## WEDDIN SHIRE COUNCIL

6 June 2022

**RE: SSD – 13855453 – Grenfell Poultry Breeder Farm  
Lot 1 DP 1022013, Lots 1-3 DP 1206485 and Lot 22 DP 866857**

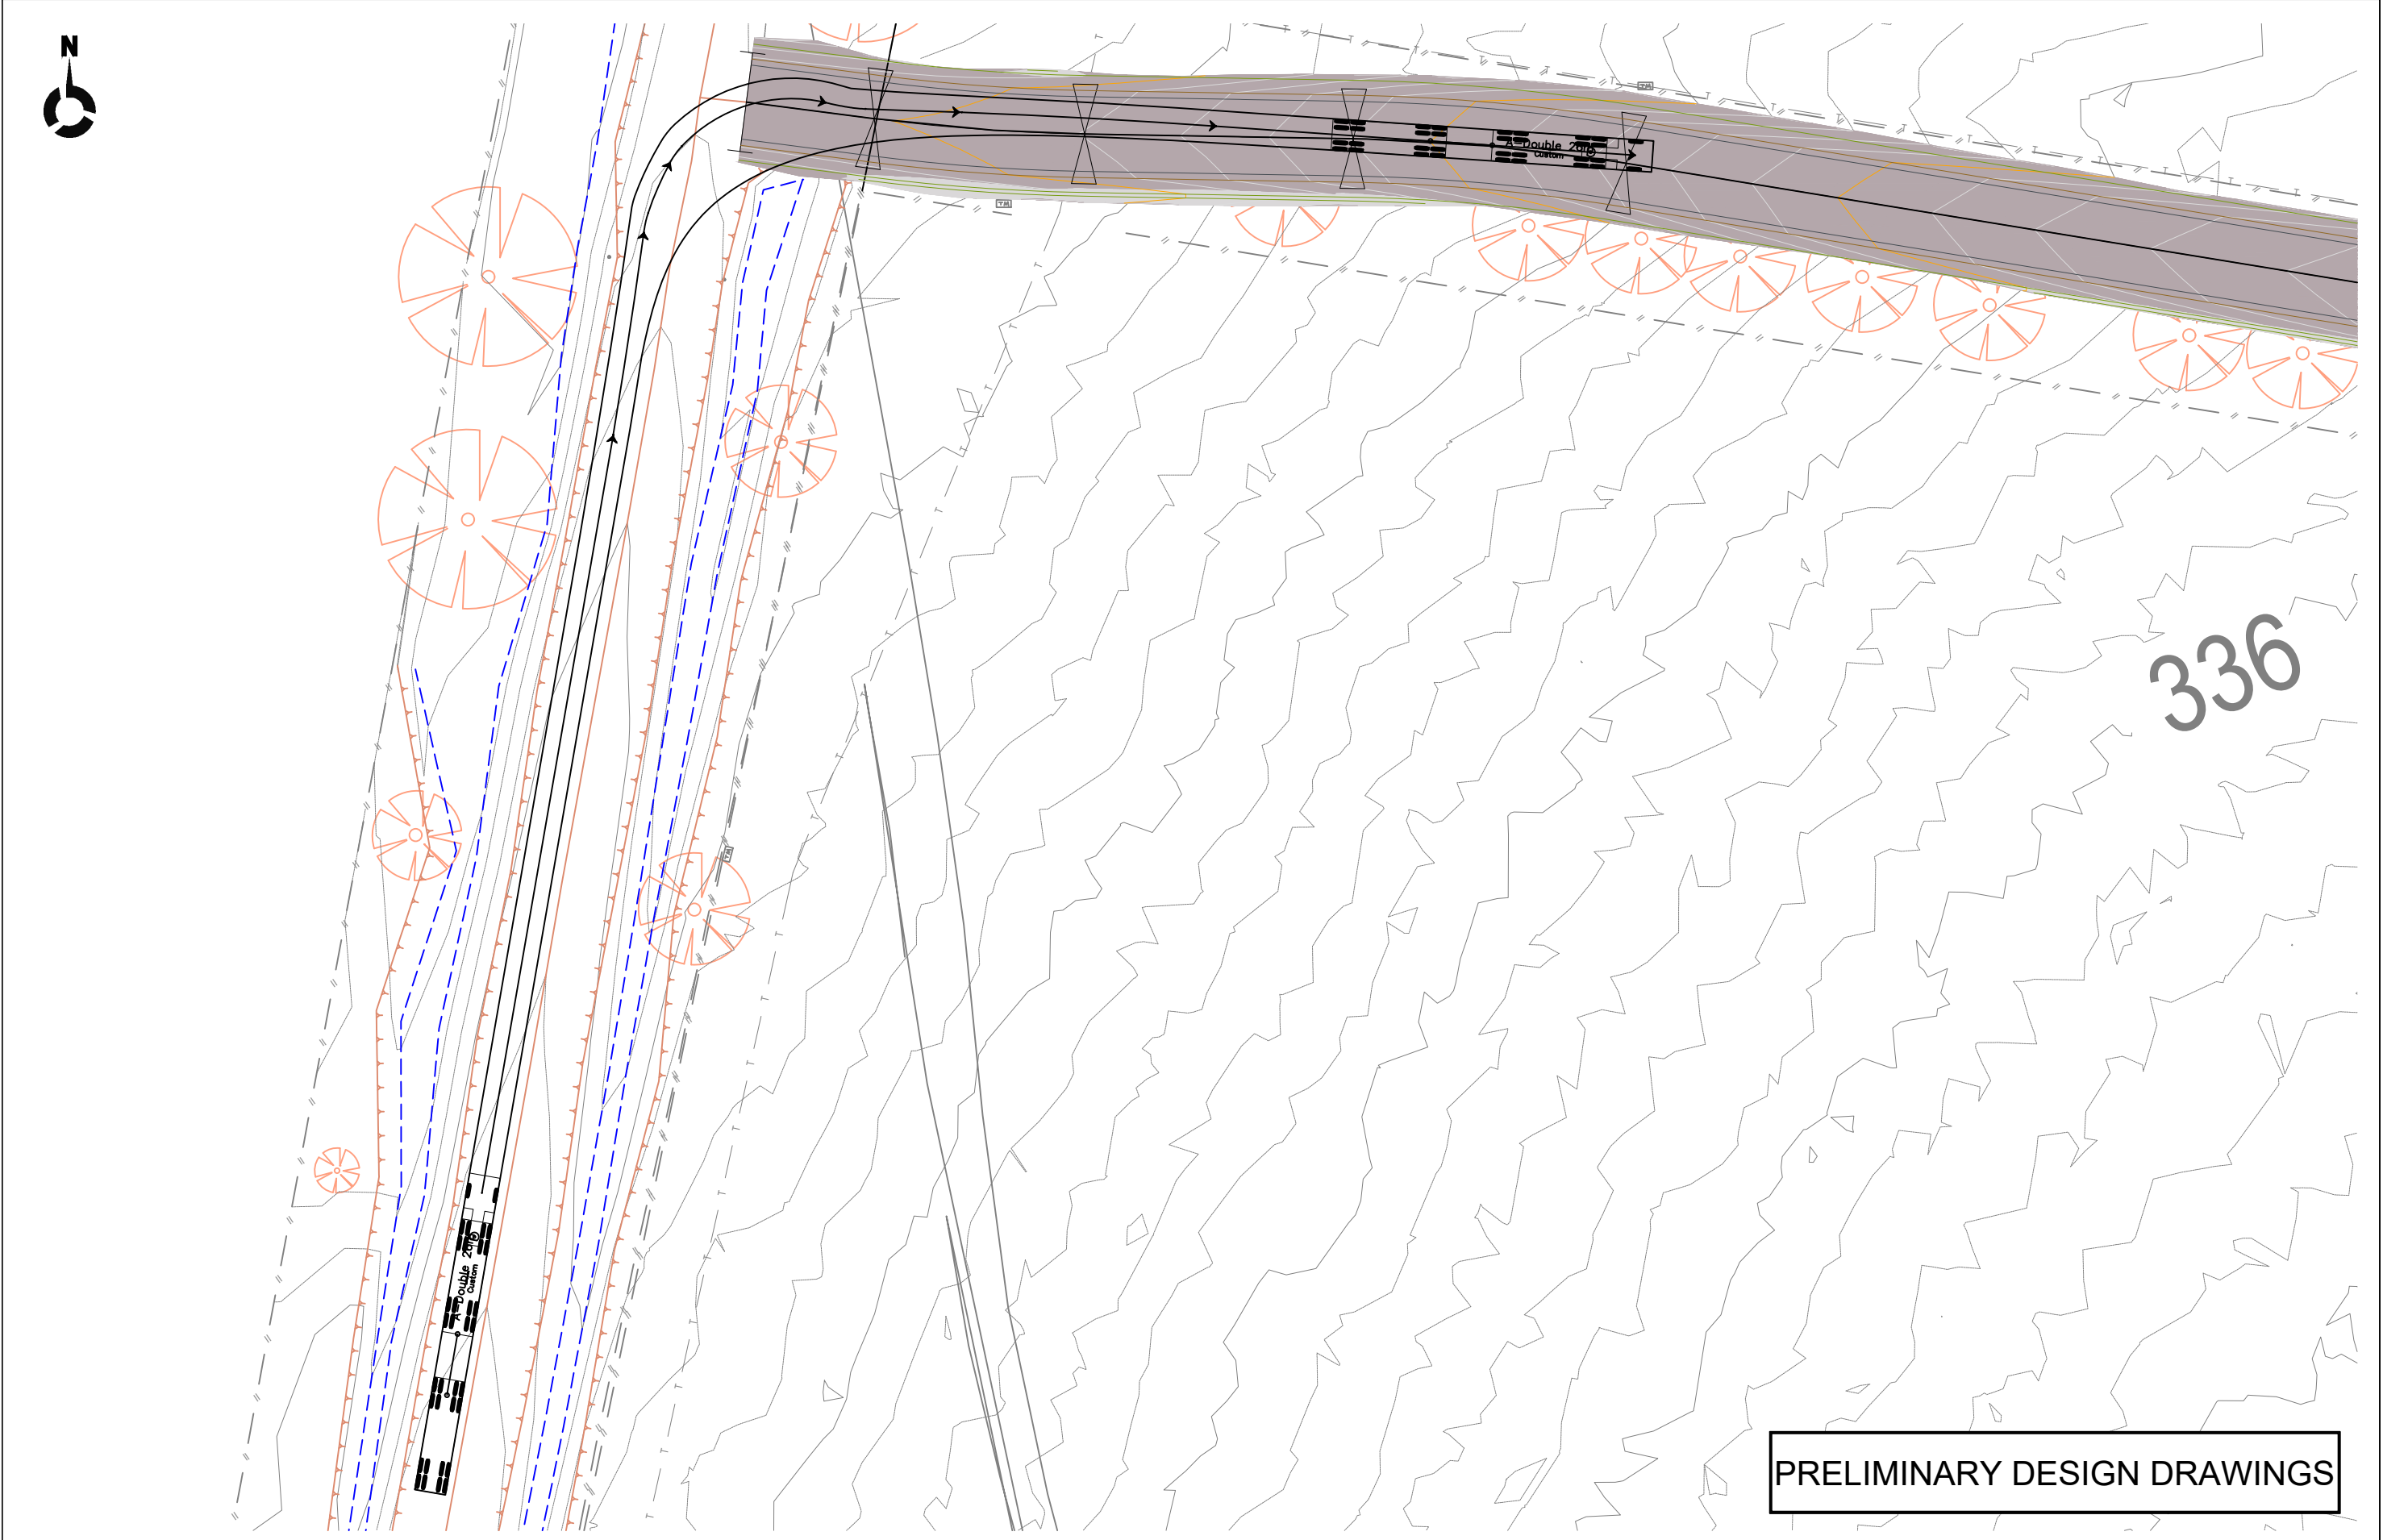
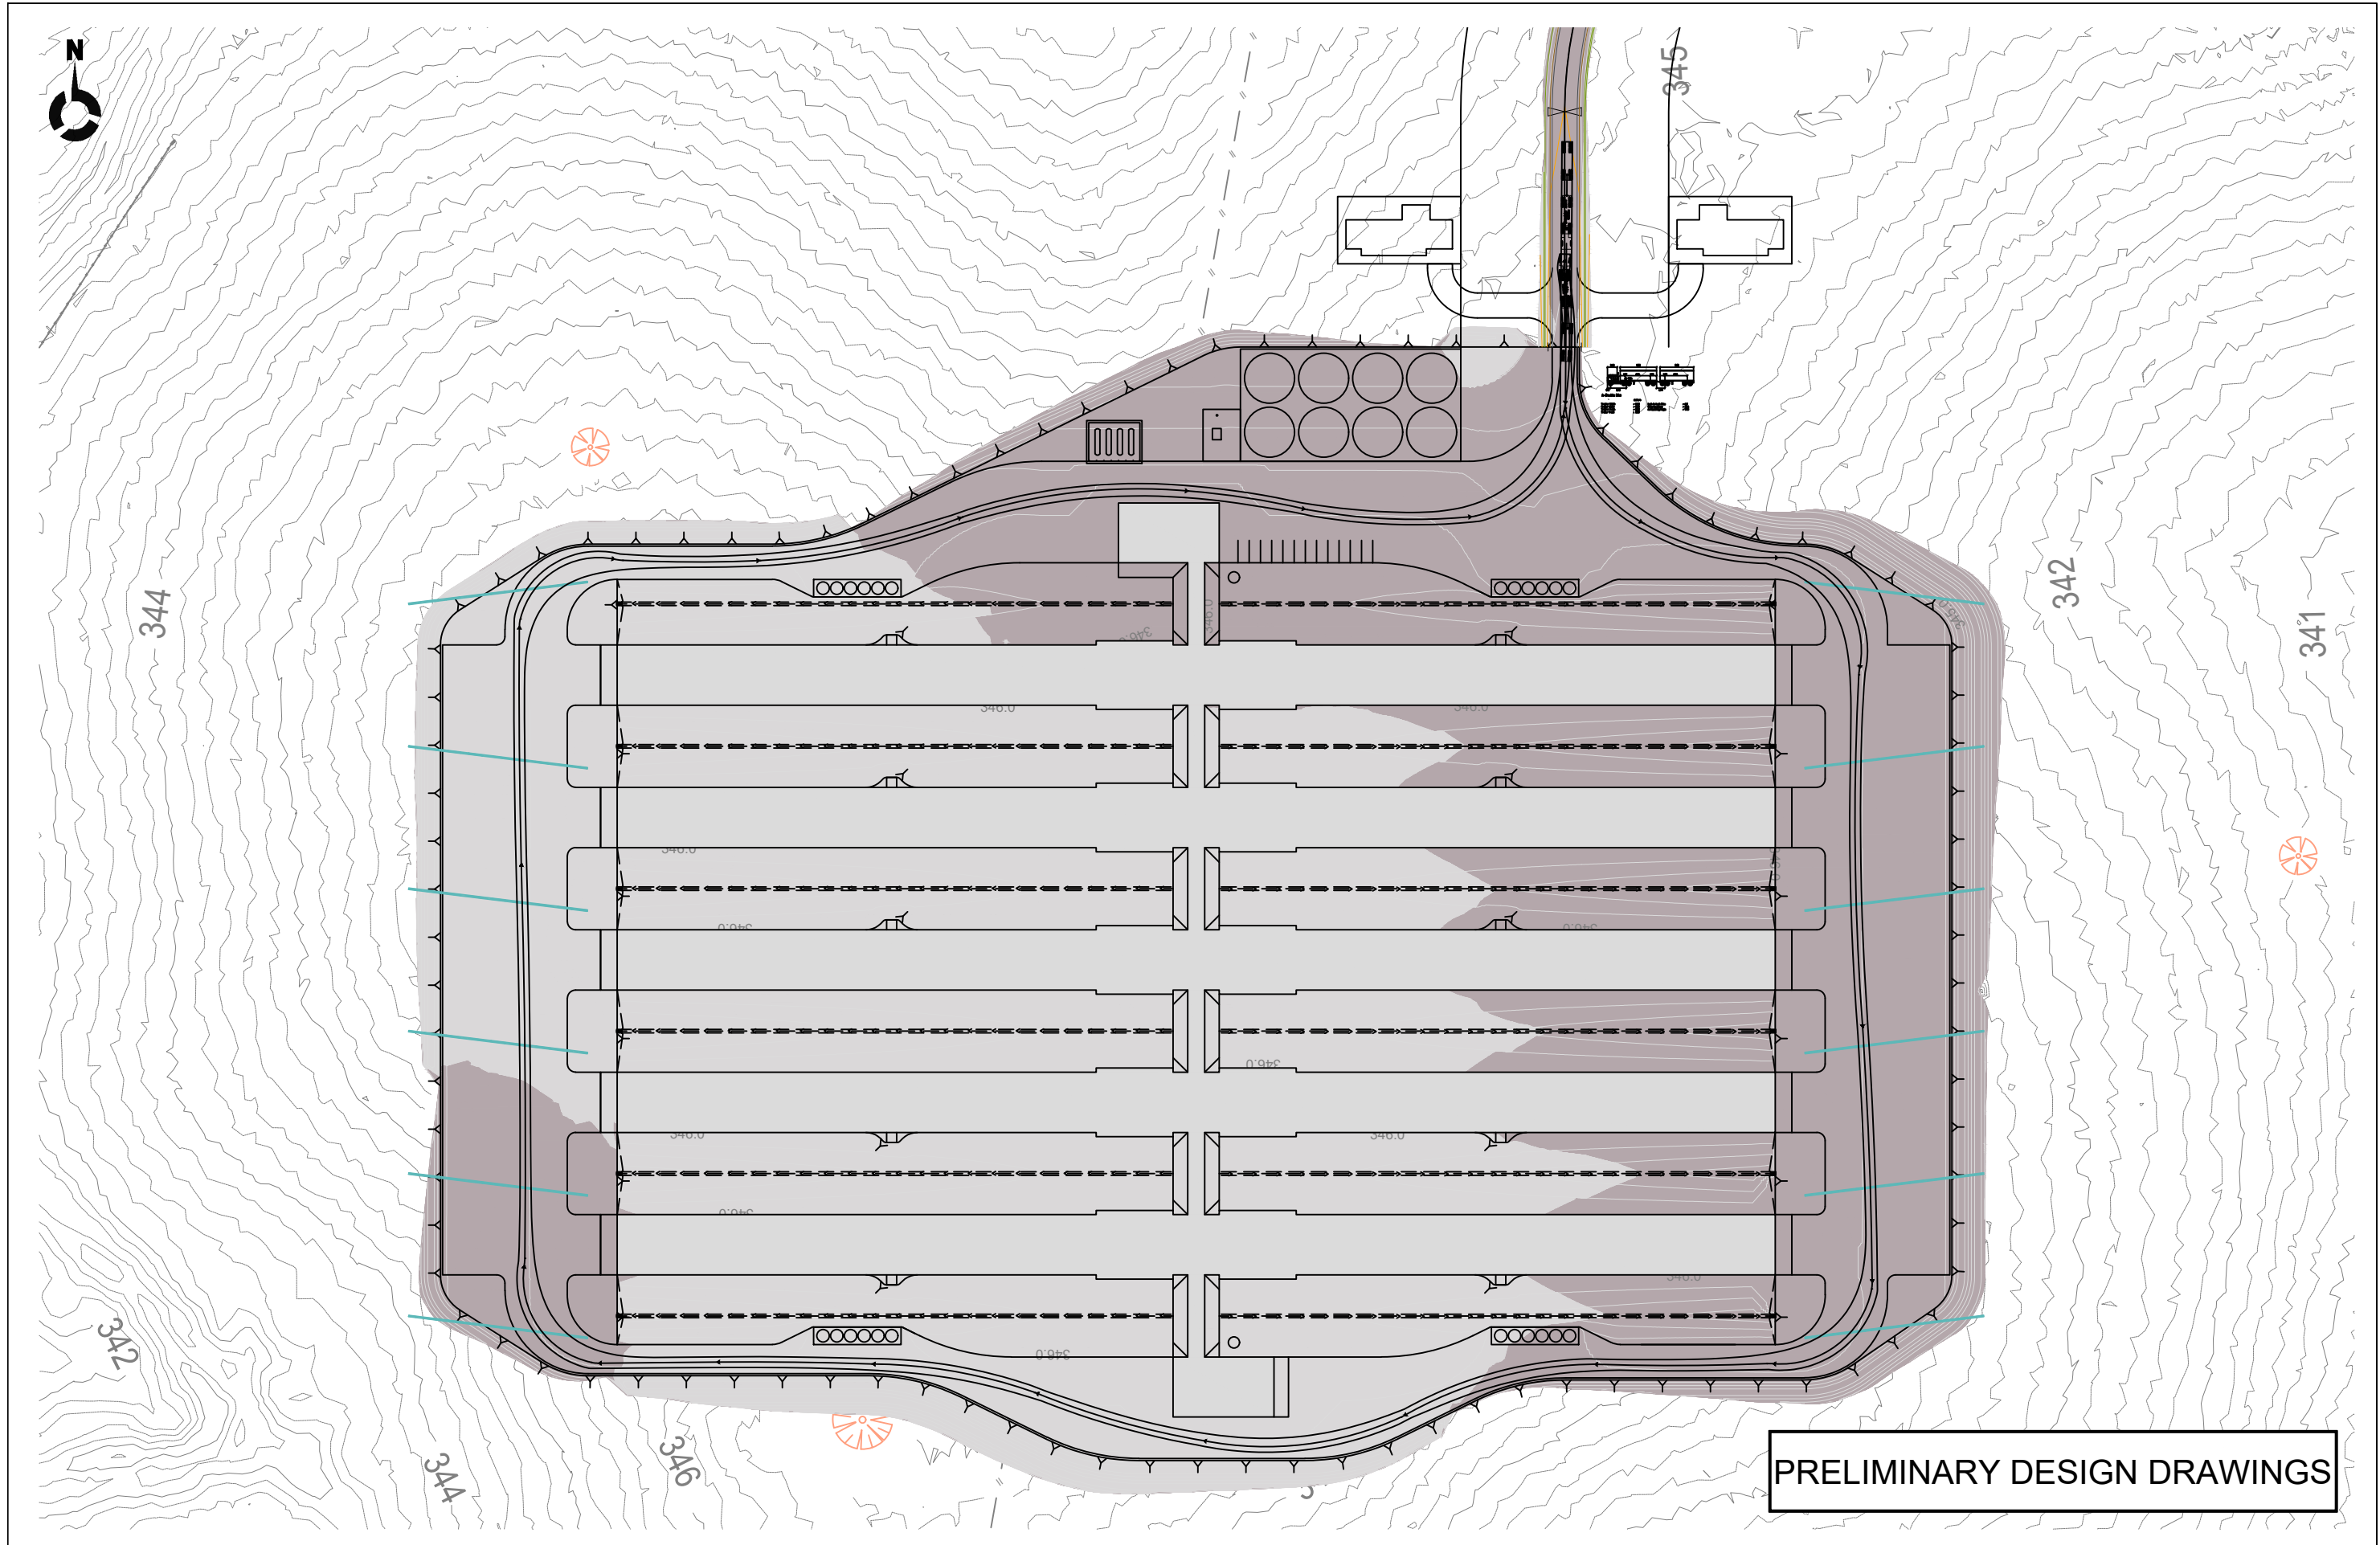
- Council is of the opinion that the proposed entry/exit is required to be modified in order to comply with Ausroads Standard to ensure that vehicles are not required to cross onto the opposite traffic lane to enter or exit the property.
